IP NUMBER [REDACTED]: FOSSE GREEN DEADLINE 4 SUMMARY

IP NUMBER [REDACTED]: FOSSE GREEN DEADLINE 4 COMMENTS

This submission is in 2 sections; Section A covers the Applicant’s responses to the ExA’s second written questions and Section B refers to the Revised Solar Technical Guide.

Plate 12-1: BESS imports solar during the day and exports in the evening

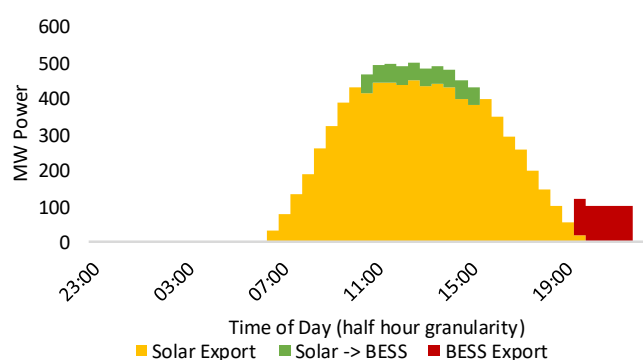
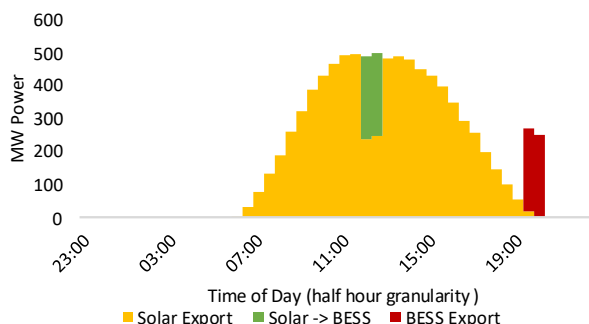
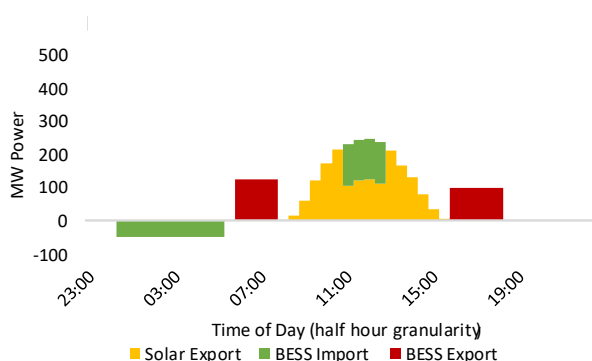
B.2.2 Plates 12-1, 12-2 & 12-3 all show a yellow area depicting solar being exported. If solar is being exported to the grid it can only come from the solar arrays associated with the Proposed Development. Plates 12-1 and 12-2 appear to be at the height of summer during the 5% of the year when maximum output is predicted. Plate 12-3 which shows ‘solar export’ peaking at above 200MWp is clearly not in winter. A more balanced view is required; eg at, say, monthly periods across the year.
